OFFICIAL NOTIFICATION OF DECISION

Project# PR-2022-007492
Application#
SD-2023-00074 – PRELIMINARY/FINAL PLAT

**LOT 18, BLOCK 4 UNIT 3, NORTH
ALBUQUERQUE ACRES** zoned **PD**, located at
**8950 ALAMEDA BLVD NE between VENTURA
ST and BARSTOW ST** containing
approximately **0.8995** acre(s). **(C-20)**

**SKETCH
PLAT**

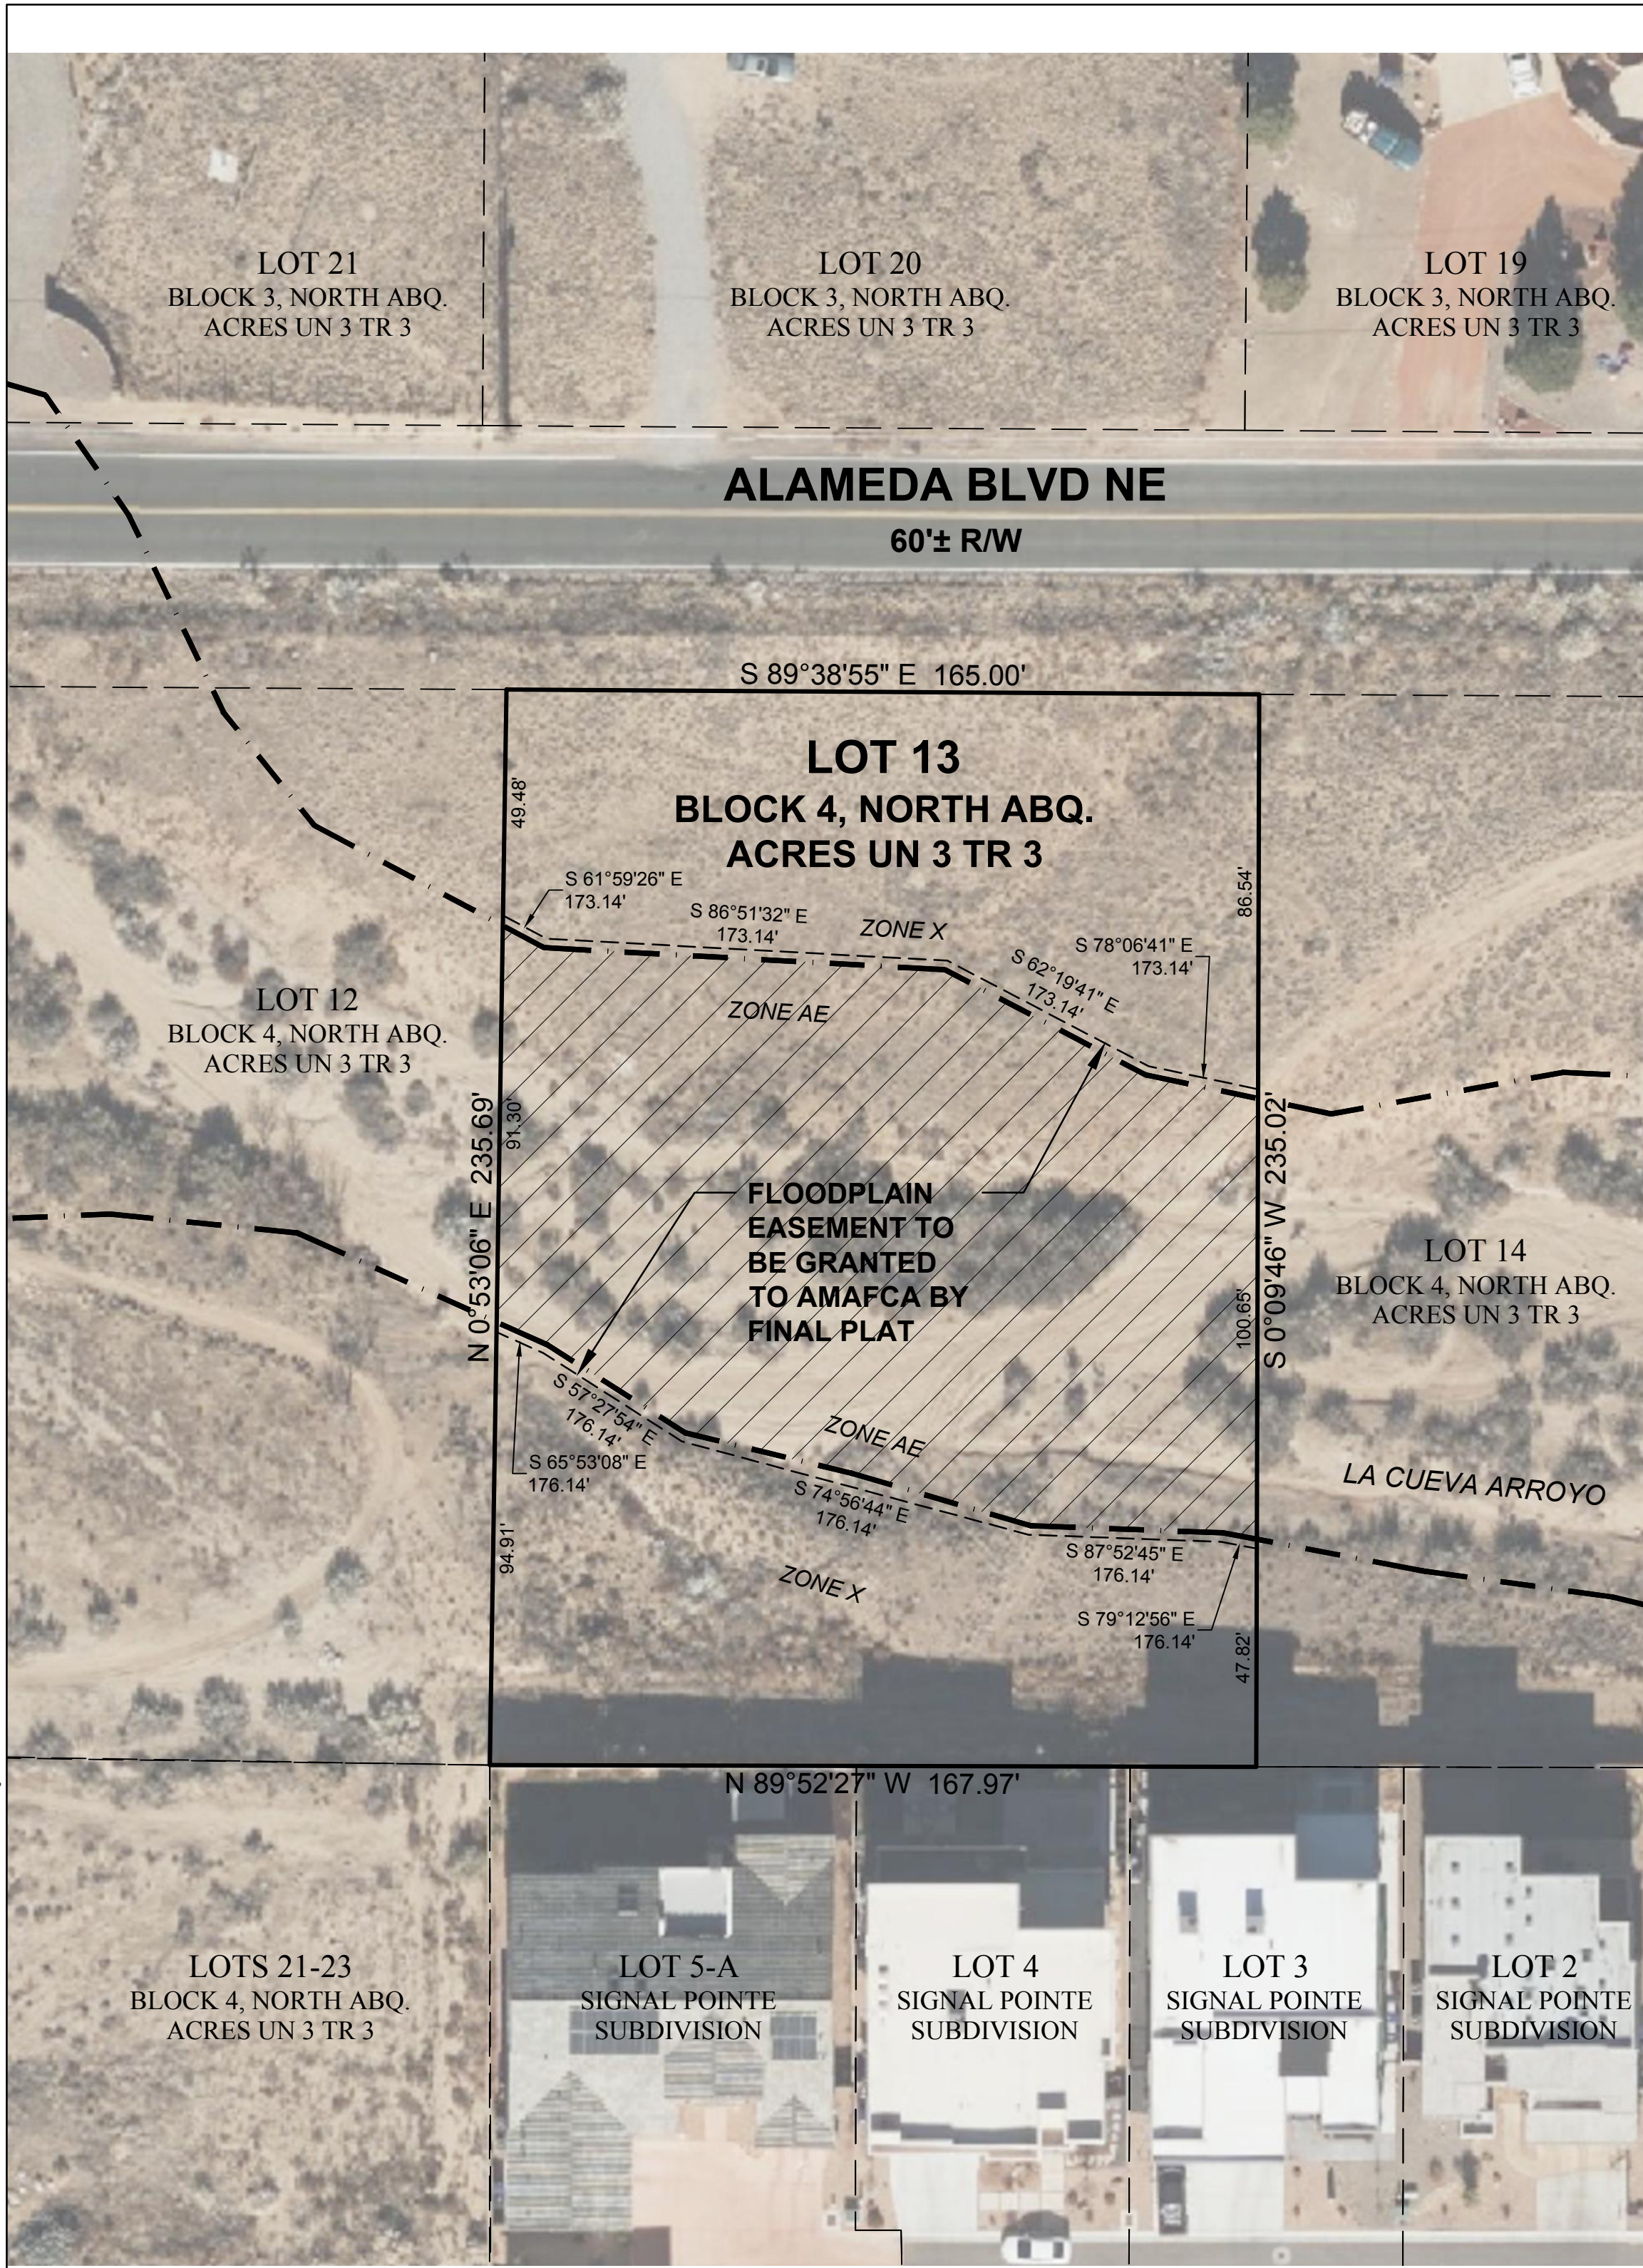
- a. The application number must be added to the Plat, the AGIS DXF file, and the recorded IIA.
- b. An additional 1-foot of right-of-way dedication must be added to the Plat for the sidewalk.
- c. If the limits of the drainage easement are approved by AMAFCA to the actual floodplain limits, a grading and drainage plan does not need to be re-submitted. If AMAFCA requires that it be shown at the present location, an updated grading and drainage plan will be required.
